Your Ref: OWPC17559
Our Ref: P/1/18/DOC 05-01-2018
Please ask for:
Mr S Davis

12th March 2018

Application for approval of details reserved by conditions imposed under planning permission P/125/14/PL relating to condition No. 10 (Refuse & recycling bins), condition No.14 (Visitor Parking Spaces), condition No.15 (Surface water onto Highway), condition No. 16 (Street Lighting), condition No. 18 (Cycle Parking), condition No. 21 (Landscaping), condition No. 22 (Screen Walls & Fences) & condition No.26 (External Lighting), condition 31 (Dog Walking)
251 Pagham Road & Land R/O Pagham

drawing title	Landscape General Arrangement (East)				
drawing no.	1896-TF-00-00-DR-L-1002				P03
scale	1:250 @ A1	date	28.09.17	drawn by	AC
				checked by	AC

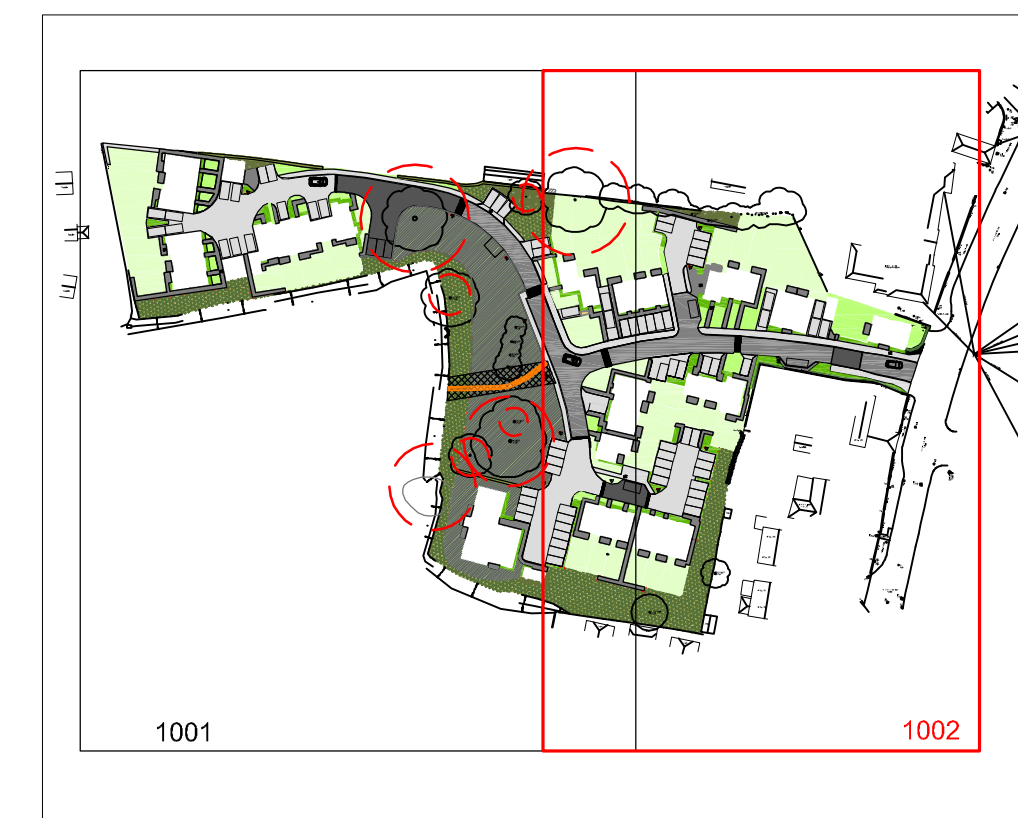
The Structural Planting along the east boundary is completely inadequate as requested by the Parish Council and individual objections to P/125/14/PL. Proper screening of development is required not token planting
